Application reference number	2025 0245
-------------------------------------	-----------

Proposal Description:	Change of use of ground floor of existing newsagents (E) into a micro pub (Sui Generis)
Location:	34 High Street, Grimethorpe, Barnsley, S72 7LP

SUMMARY

Drawing Title:  
General Arrangement

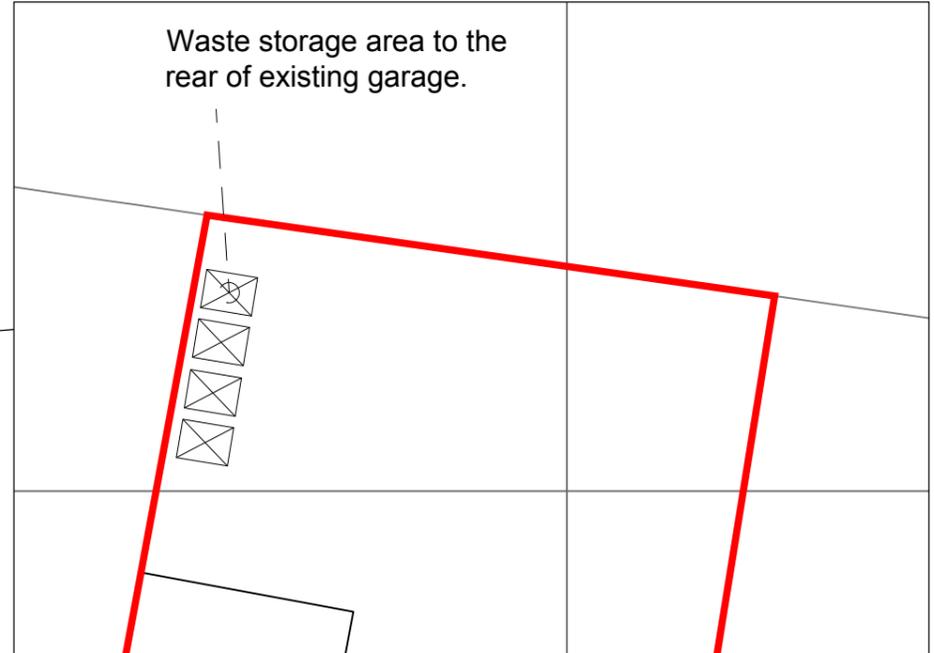
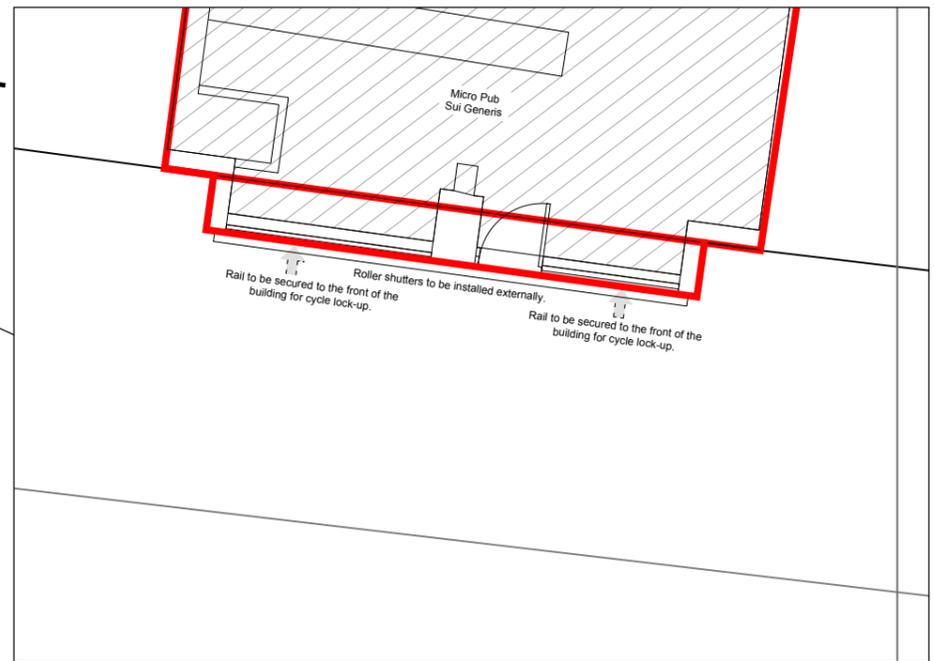
Waste and cycle parking plan – waste storage bins to rear of garage; cycle rails to be secured to front of building for cycle lock-up

Highways DC – No objections subject to conditions relating to provision of cycle parking and bin storage/collection points.

- In response to reconsultation on amended details the waste storage and collection and a low level steel rail attached to the building for cycle parking is acceptable.

Drawing Title:
General Arrangement

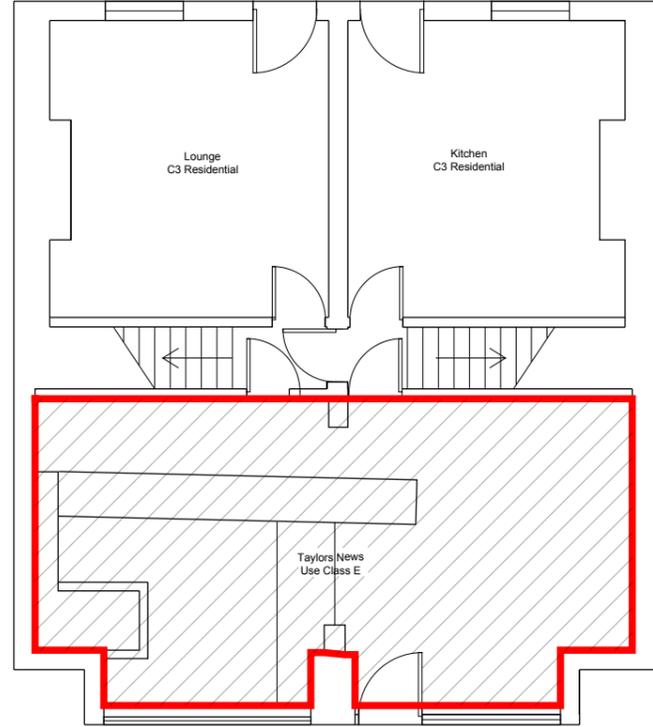
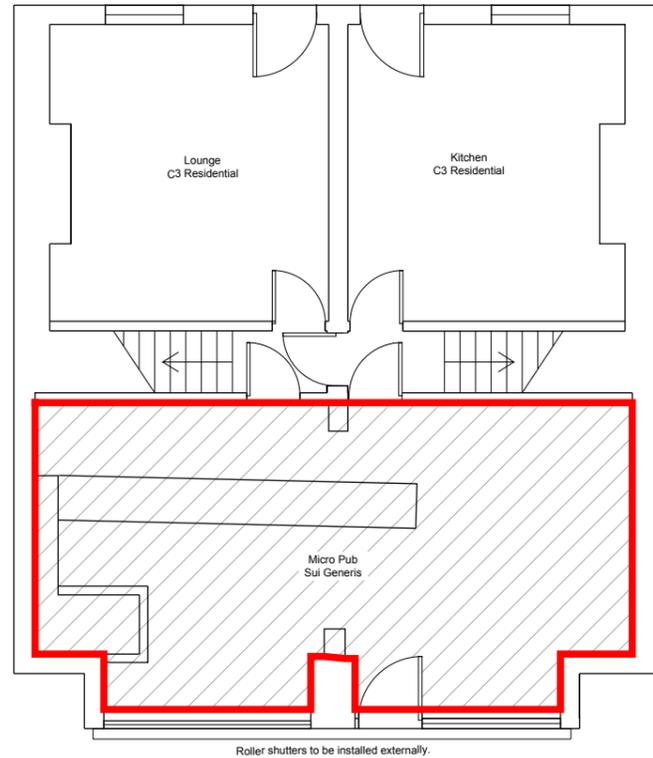
- The plan notes that the proposed lounge and kitchen areas of the micro pub are to be located at the rear of the property with windows directly overlooking neighbours garden(s) leading to loss of privacy and enjoyment of garden.

09. The use hereby permitted only relates to the area specified on the approved general arrangement plan and there shall be no use by customers of the remainder of the ground floor, first floor or the rear garden area.
